Recommendation Report for Planning Permission for Works or Extension to a Dwelling

REF NO: BR/82/20/HH

LOCATION: 25 Westingway
Bognor Regis
PO21 2XX

PROPOSAL: Single storey rear extension.

Proposed Rear Extension
at 25 Westingway, Bognor Regis
for Mr and Mrs I Taylor
Drawing P02 March 2020 Scale 1:100 @ A3
Planning Drawing -Block Plan & Location Plan

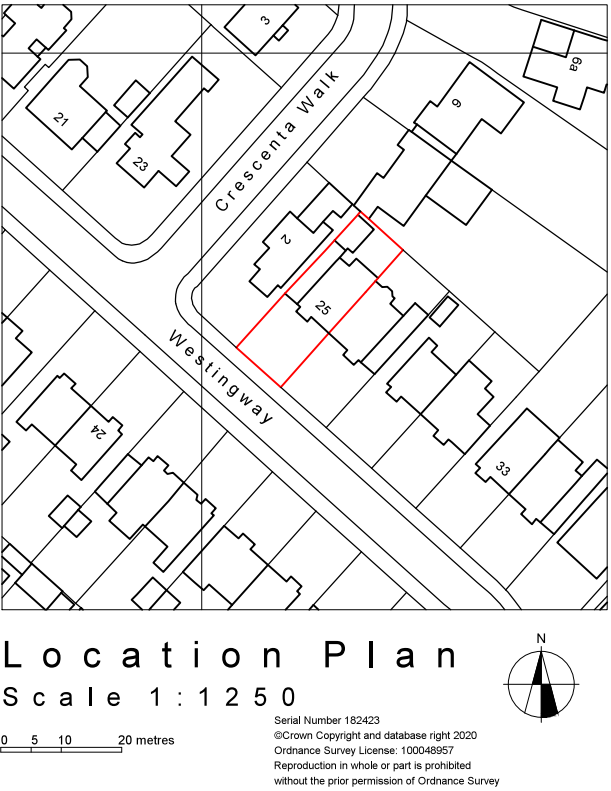
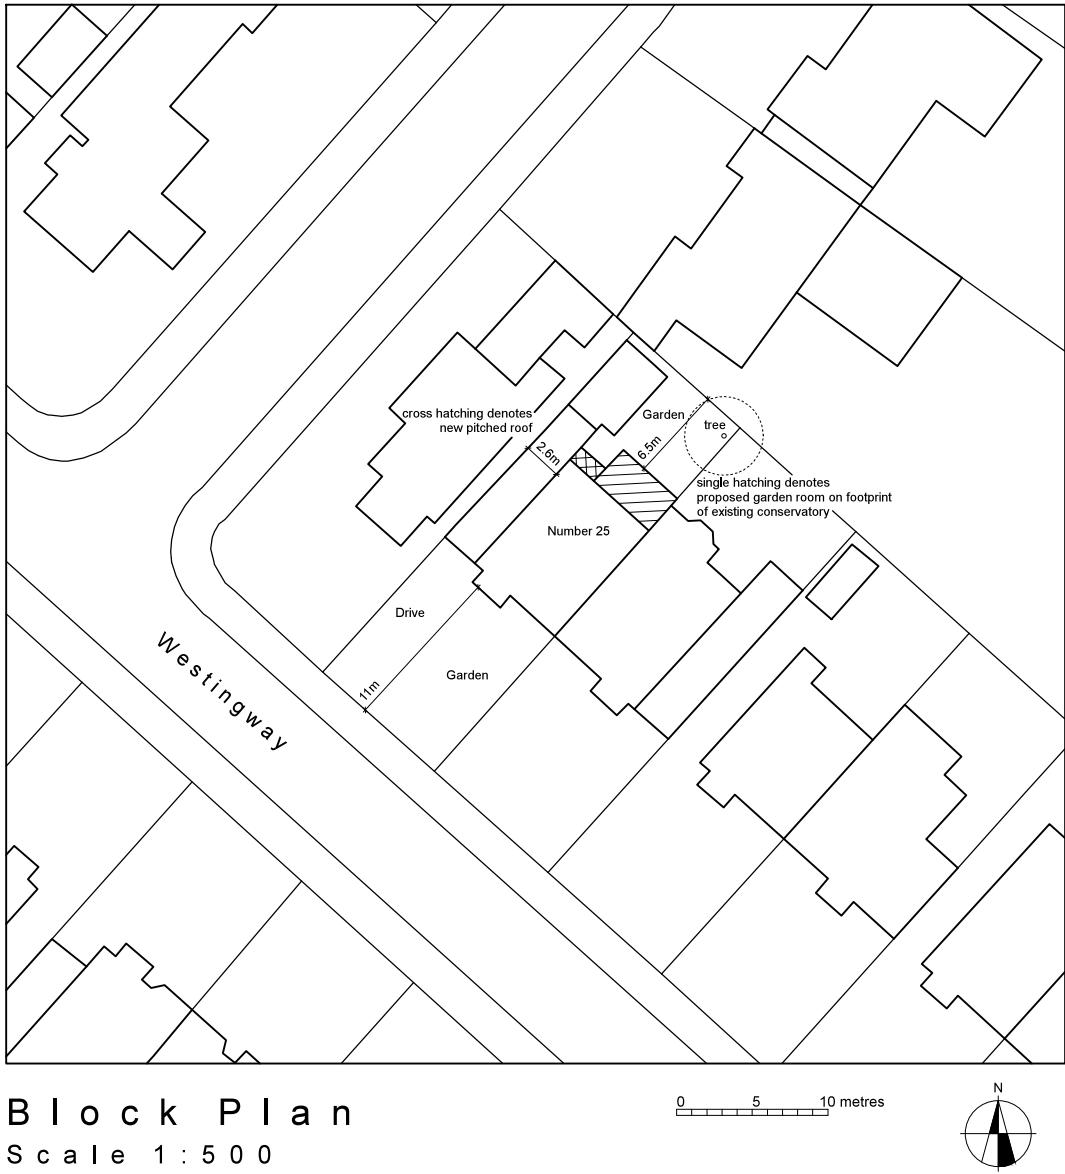
Comments noted. Development should be on land within the ownership of the applicant as shown on the red edge on the plan. Party Wall Agreements are a private matter.

Drawing P01 March 2020 Scale 1:100 @ A3
Planning Drawing - Floor Plan, Roof Plan and Elevations

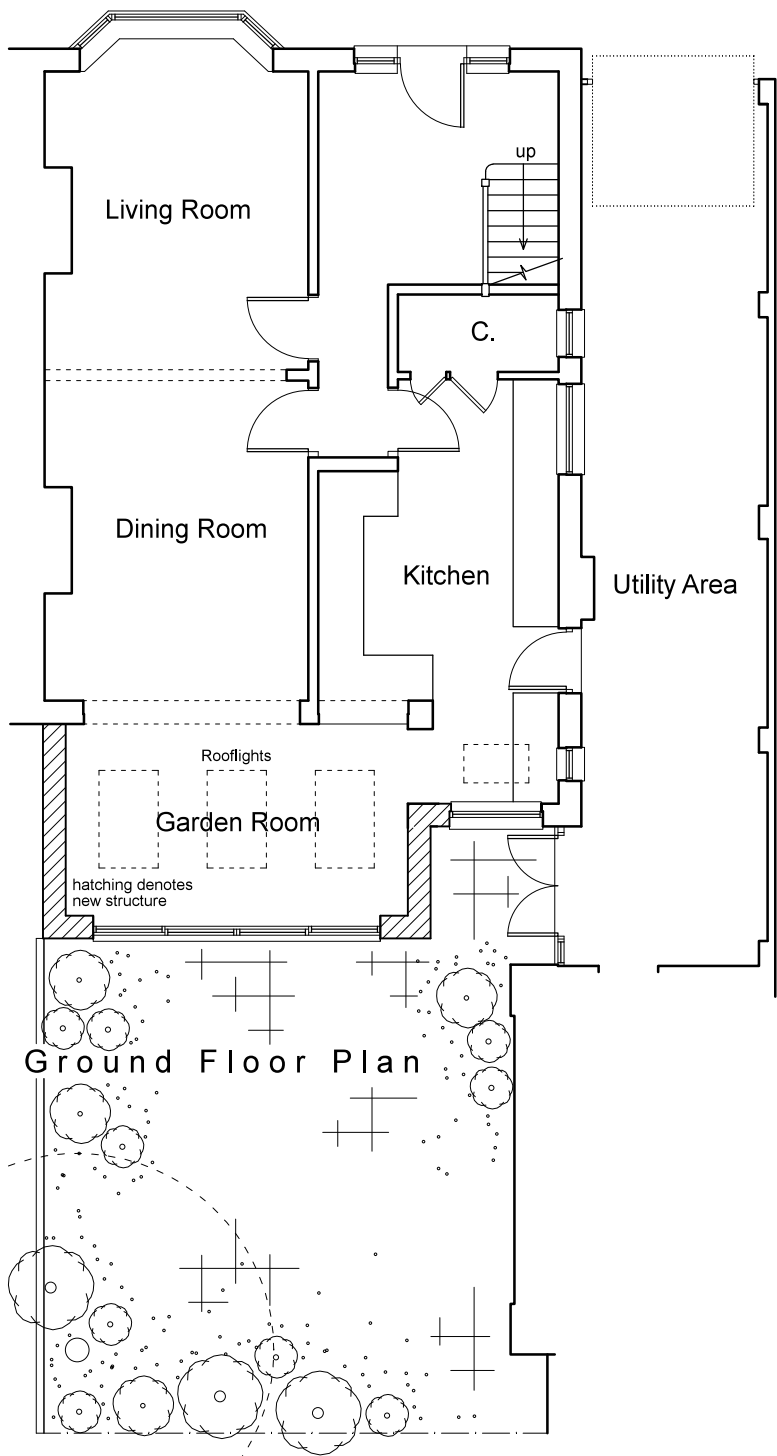
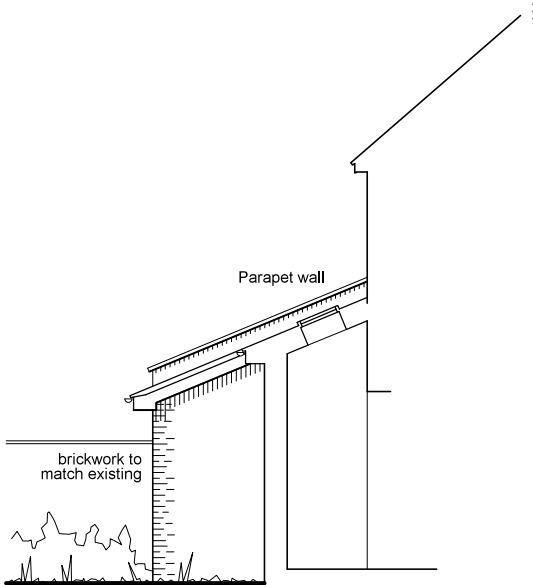
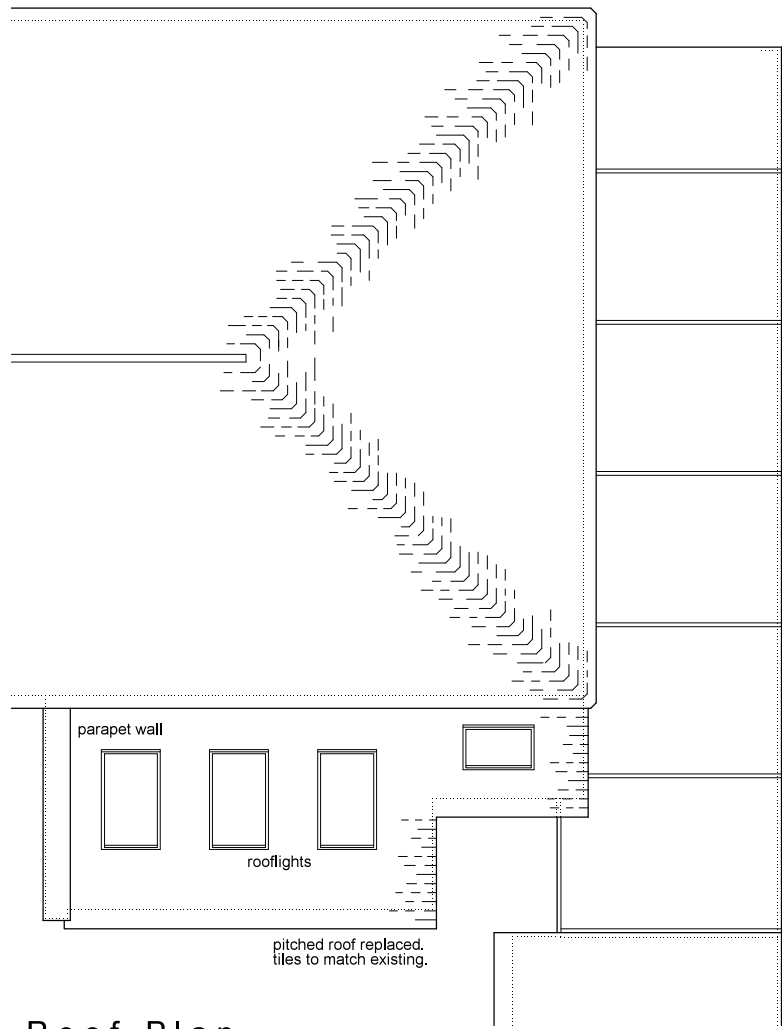
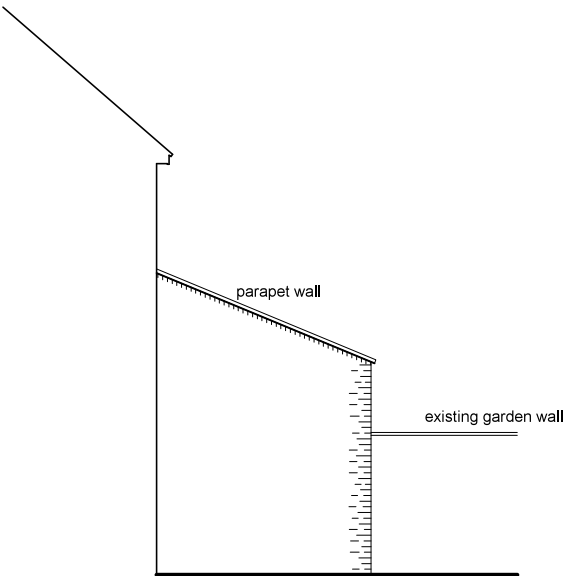
The extension will have a modest depth of 2.85m. This is the same as the existing conservatory however the roof will alter from a flat roof to a lean to roof. The roof will have eaves height to 2.4m with a maximum 3.65m.

There is a utility area to the north western elevation of the property and the extension will reduce in depth to this elevation to approximately 1.4m which will allow for rear/side access to this area.

There is however sufficient distance retained to the western elevation to ensure there is no adverse impacts upon amenity.

The extension will sit at the boundary to the east, with the elevation consisting of brick construction. This is the same as the existing development. The extension does extend marginally beyond the neighbouring property's conservatory however this is again similar to the existing and is not considered to result in an adverse impact by way of overbearing or overshadowing.

There will be doors along the rear and 3 rooflights, however due to their height above finished floor level are not deemed to result in adverse overlooking.
